Dean Moor Solar Farm

PLANNING INSPECTORATE REFERENCE EN010155

Council Response to ISH Hearing Agenda Items (Annex A)

30 September 2025

Environmental Statement: Chapter 7 – Figure 7.4b Zone of Theoretical Visibility DTM with View Locations

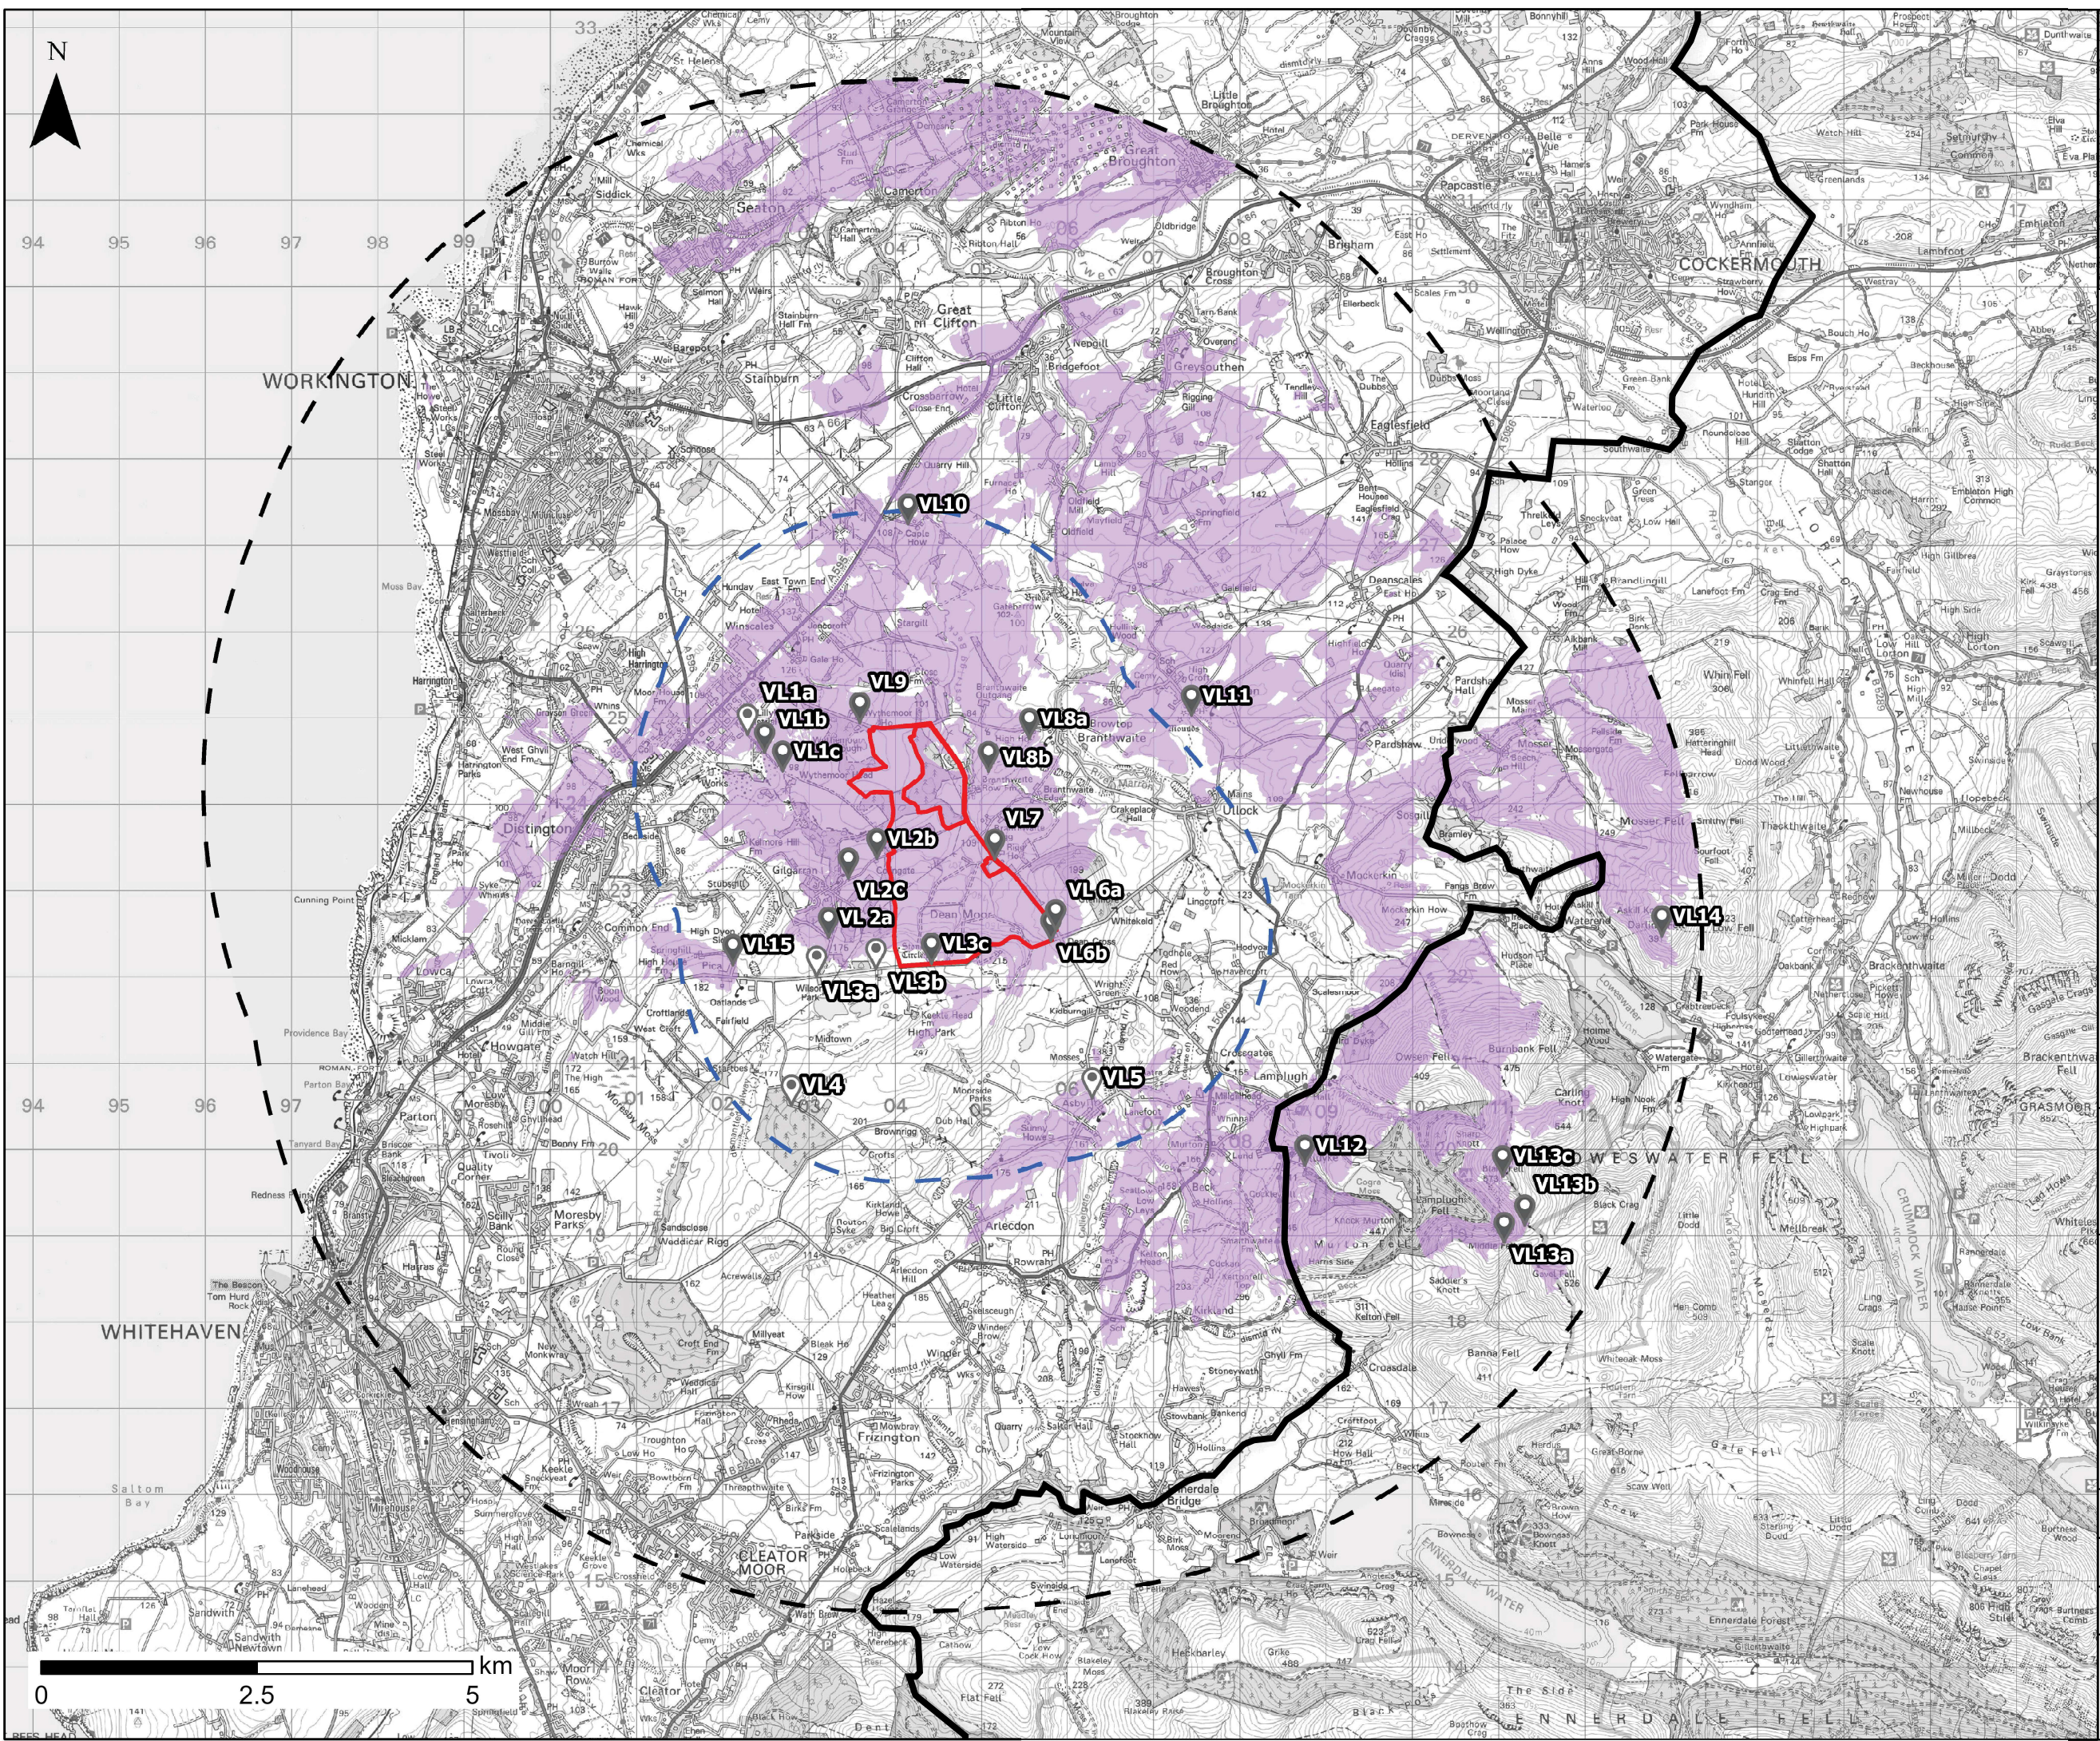
- The provision of additional ZTVs would be beneficial to show the visibility of Areas A, B, and C to demonstrate the worst-case scenario of the theoretical visibility of the Proposed Development.
- The selection of VL2b and VL3c are not representative of the worst-case views.
- The photography from some of the VLs is unclear.
- Additional planting of woodland and/or hedgerow trees along the west of Branthwaite Edge Road would be beneficial to provide adequate mitigation.

These matters are currently subject to ongoing discussions with the Applicant. However, the Council accepts that these issues do not represent fundamental differences of opinion in terms of the outcomes or the approach taken to the assessment. They reflect reasonable differences in professional judgement between independent landscape experts and do not represent a more fundamental conflict.

DEAN MOOR SOLAR FARM
NVC REPORT
APPENDIX 8.2

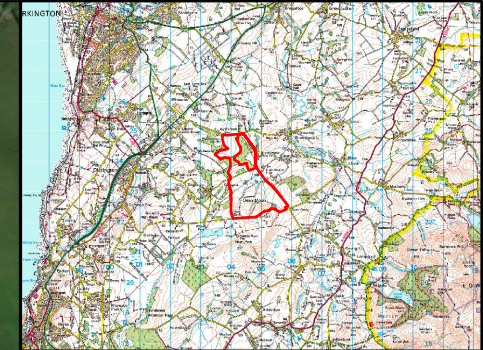
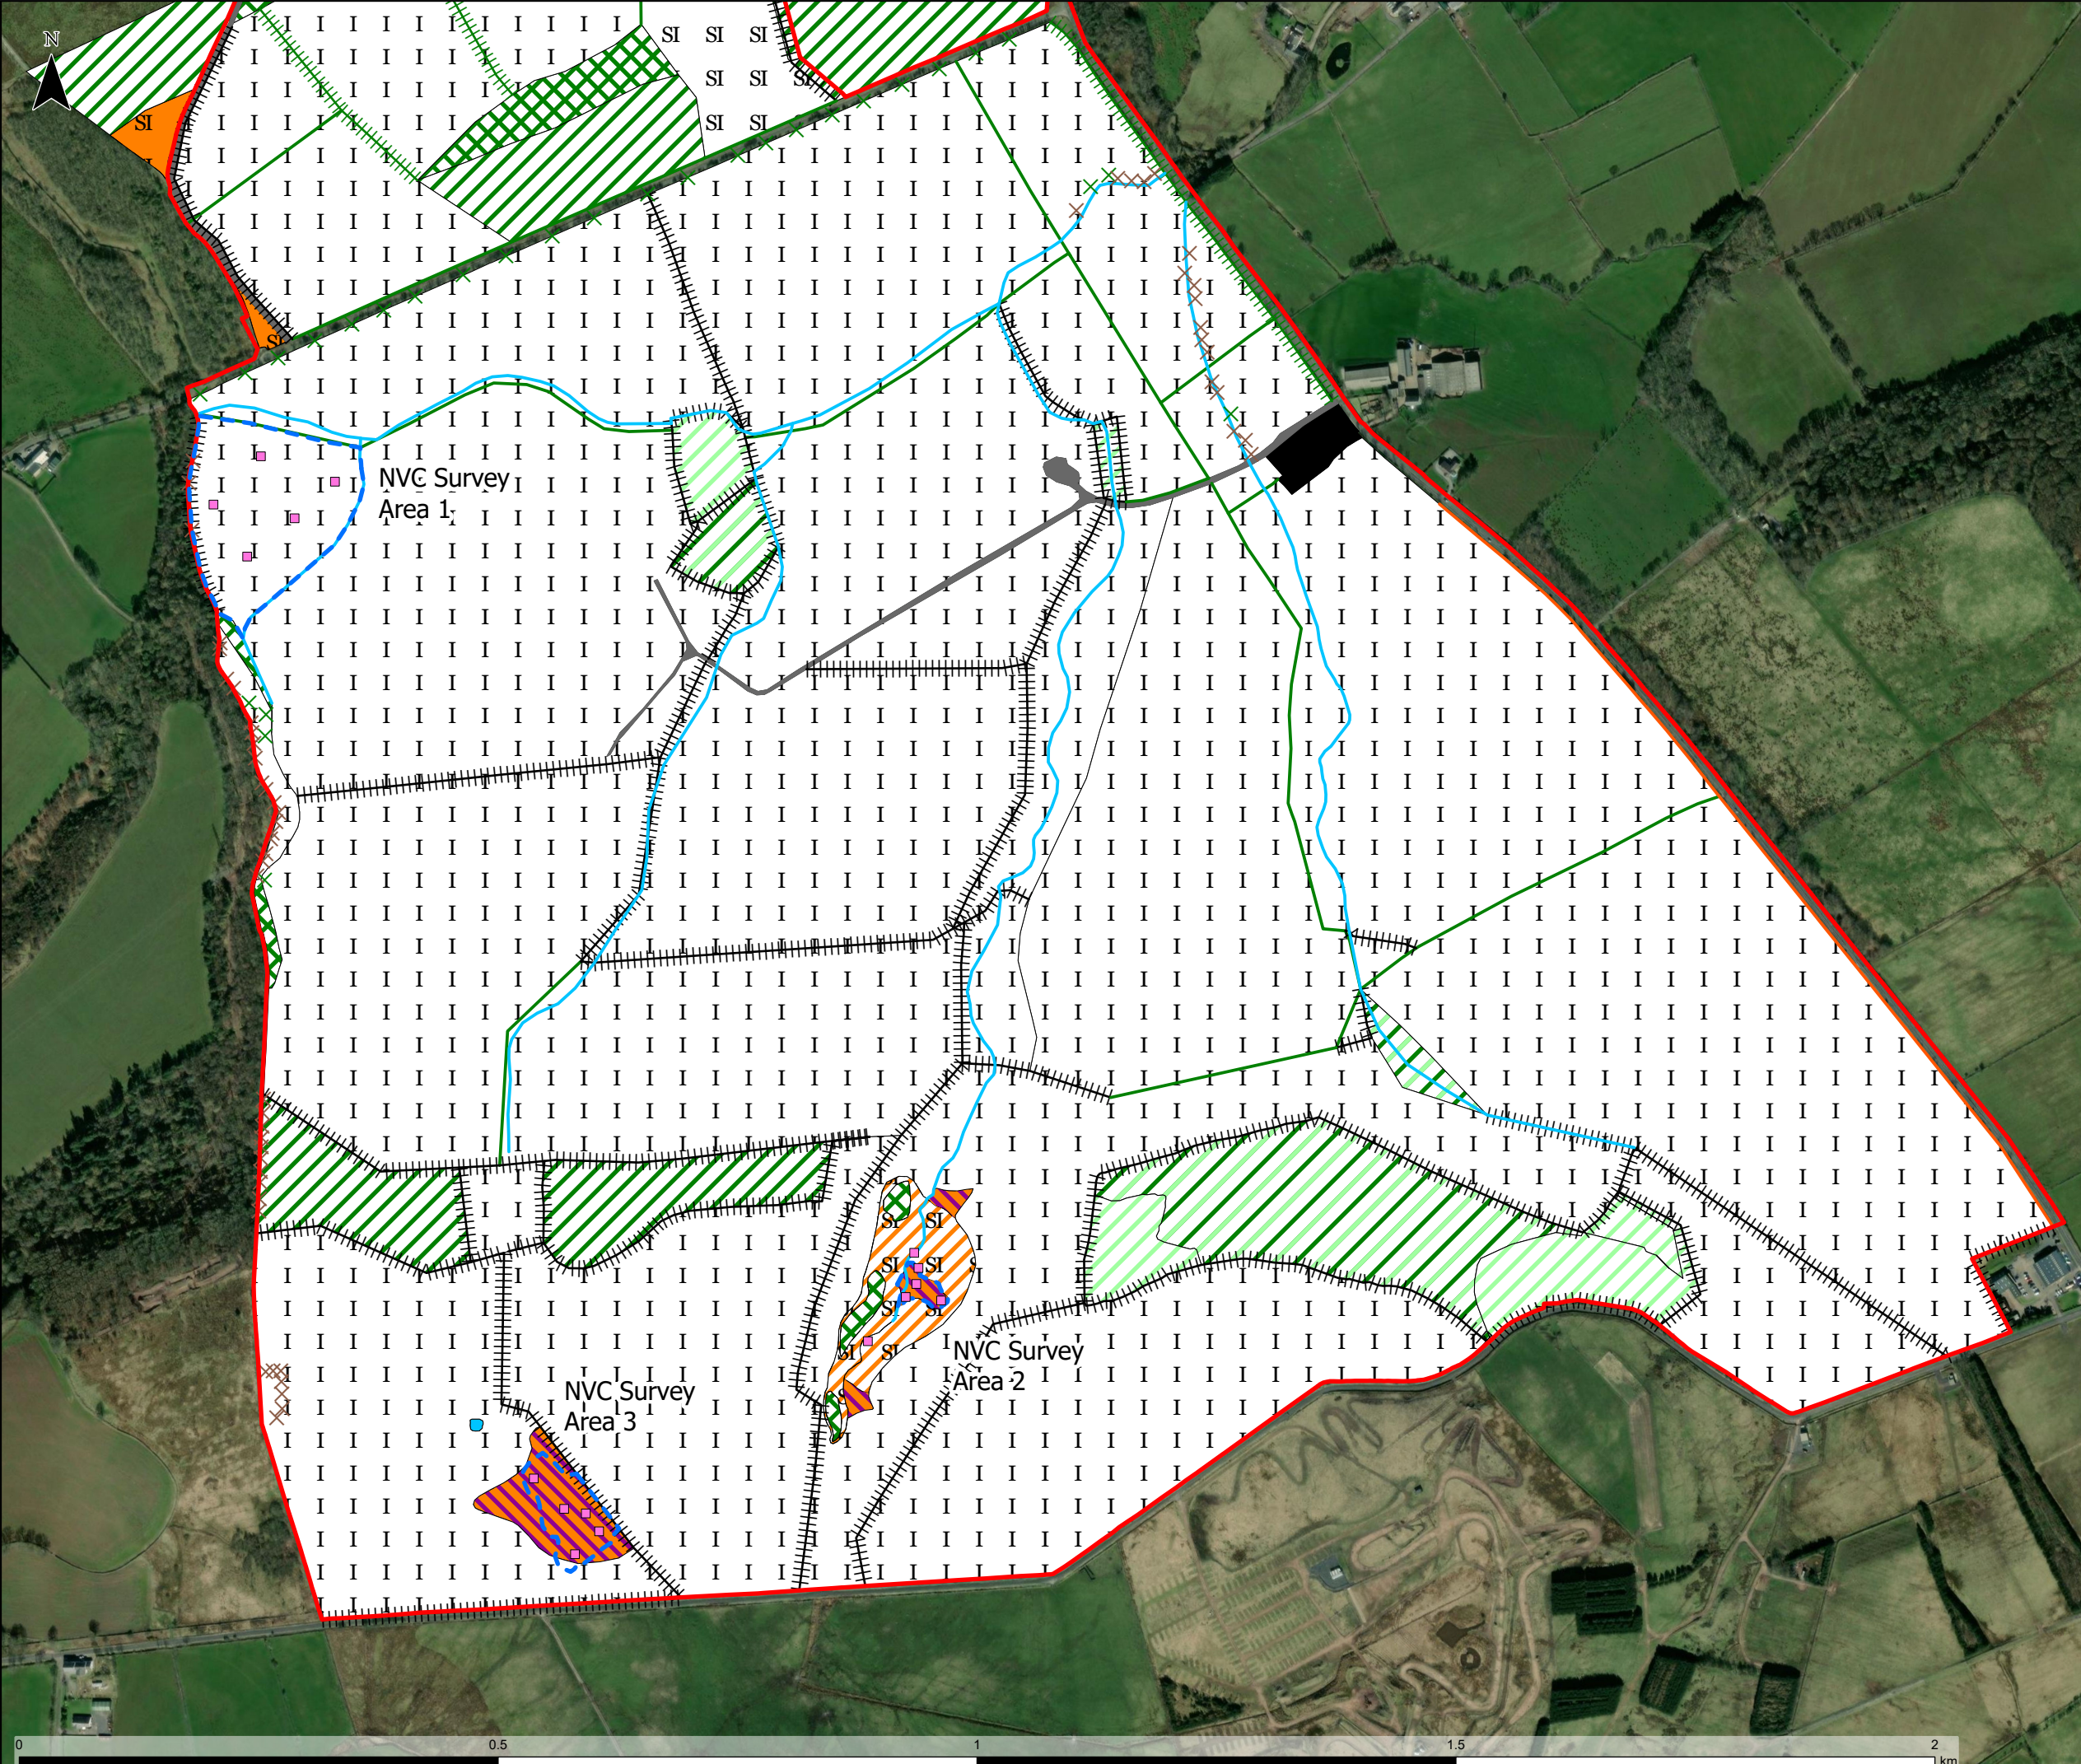
12.30 Inconsistencies in habitat mapping between BNG and NVC reports	Any inconsistencies in mapping should be rectified, with new maps provided as required. The habitats as reported in the BNG should correspond with habitats in the NVC report, or appropriate justification should be given.	The applicant response provides appropriate justification for these inconsistencies. Habitat mapping for the BNG update should correspond with the NVC report or appropriate justification provided.

Map the full extents of each assessed NVC community.	
	12.39 Survey methodology	An explanation should be included in Section 2.1 as to why and how survey areas 1, 2 and 3 were selected, and as such why were notable habitats such as lowland fen, acid grassland and species-rich neutral grassland were omitted from the assessment.	Sufficient justification has been provided for the selection of survey areas (hydrological dependant and therefore sensitive to impacts). If the NVC survey is repeated as part of the LEMP, the selection of areas for survey should be reassessed using the updated PEA information. Any notable/priority habitats should be surveyed or appropriate justification given.

12.40 Inconsistencies between BNG and NVC reports	The habitats as reported in the BNG should correspond with habitats in the NVC report, or appropriate justification should be given.	The applicant response provides appropriate justification for these inconsistencies. Any habitat classifications based on interpretation of data and professional judgement, should be supported with justification/explanation. Conversions between classification systems should be clearly presented with references stated.
